# SOILS AND GEOLOGY REPORT

## Colvin Heritage Farms

May 19 2021

Site Plan

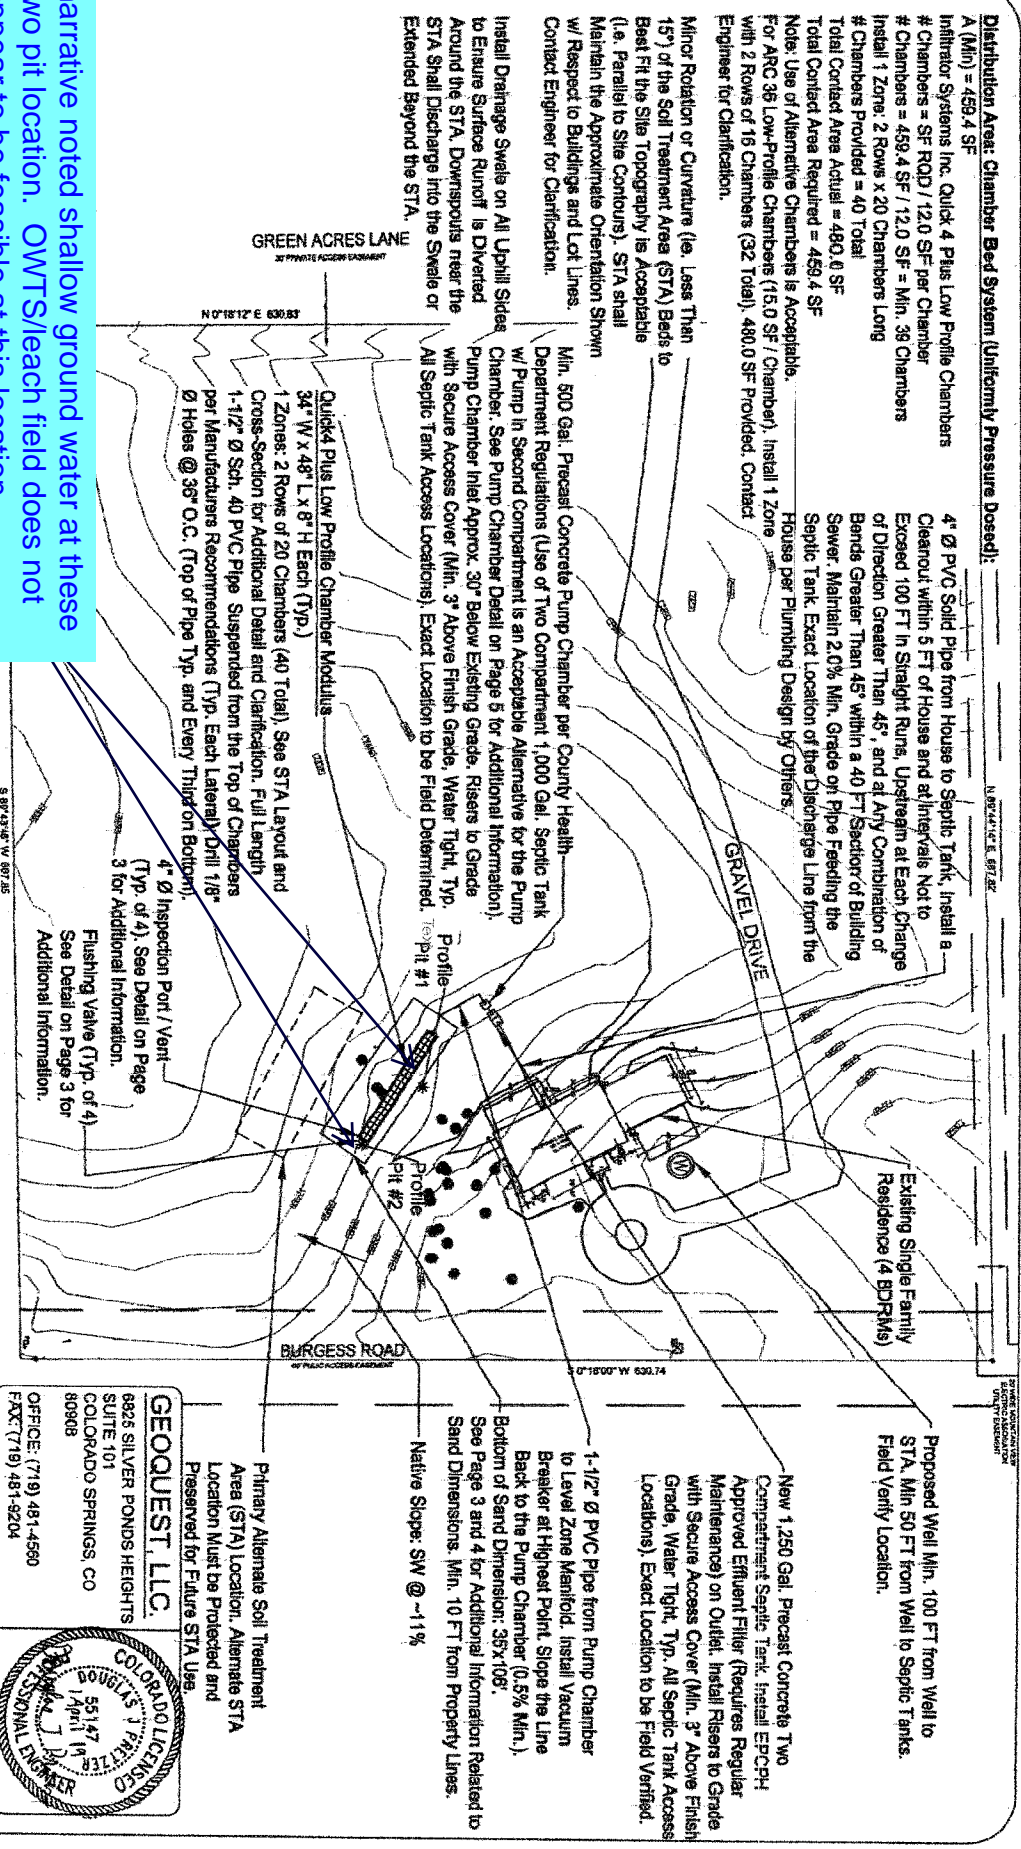
Per previous comment, areas of shallow groundwater or potentially shallow groundwater will need to be depicted and designated as no-build areas. Exhibit provided depicts a drainage easement. Is this the area of shallow groundwater? This area needs to be designated as no-build and depicted as seasonal groundwater area on the map and on the plat if so.

Per LDC Sec. 8.4.9(C)(2)(a), please revise map exhibit to include the following:

The locations of test holes, percolation tests, soil investigation test pit excavations, and other specific sources of subsurface information utilized by the geologist or qualified engineer of record shall be indicated on the map and on any sections that are submitted with the geology and soils report.
